20<sup>th</sup> December, 2004

Mr Sebastian Roberts  
General Manager  
Electricity Group  
Regulatory Affairs Division  
Australian Competition Consumer Group  
GPO Box 520J  
MELBOURNE VIC 3001

Re: Proposed Wollar-Wellington 330KV Transmission Line

**Diagram 3.1 –Transmission Network in the Western Area of NSW**

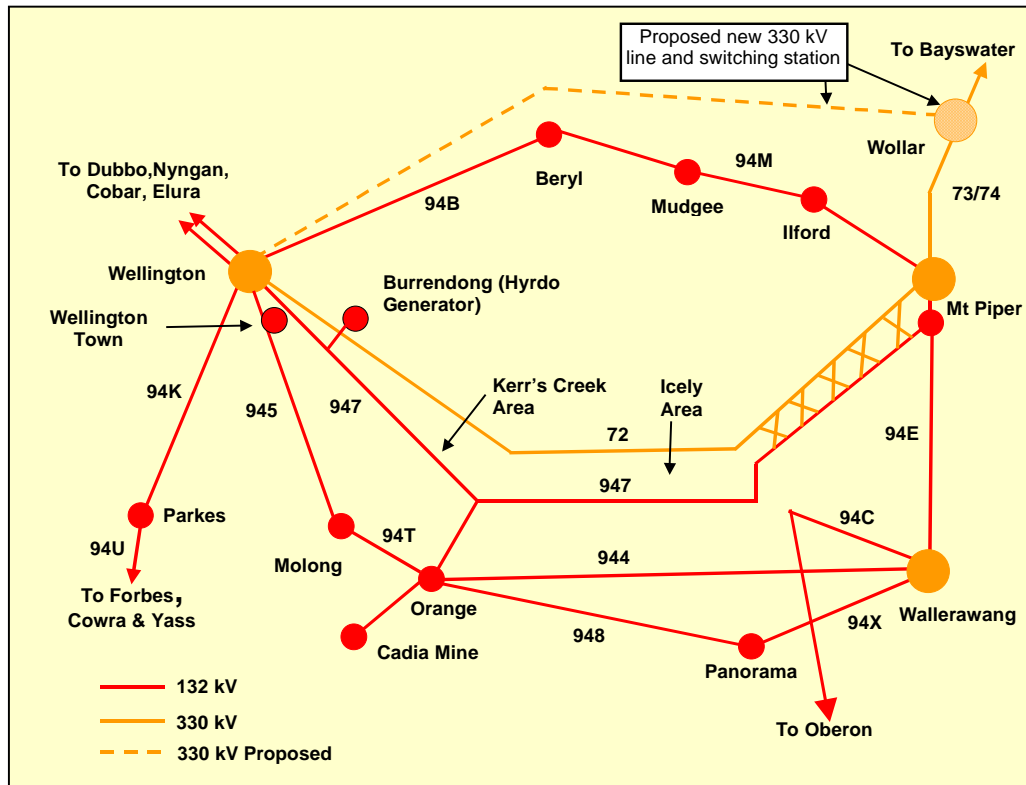
Diagram 1 & 2 Transmission Network in the Western Area show two 132 KV power lines providing power to Dubbo, Nyngan, Cobar, Bourke etc.

Question 16. Do both of the two 132 KV lines from Wellington to Dubbo continue on to Nyngan, Cobar, Bourke etc. if not, where does the supply reduce to one 132 KV line and or 66 KV line?
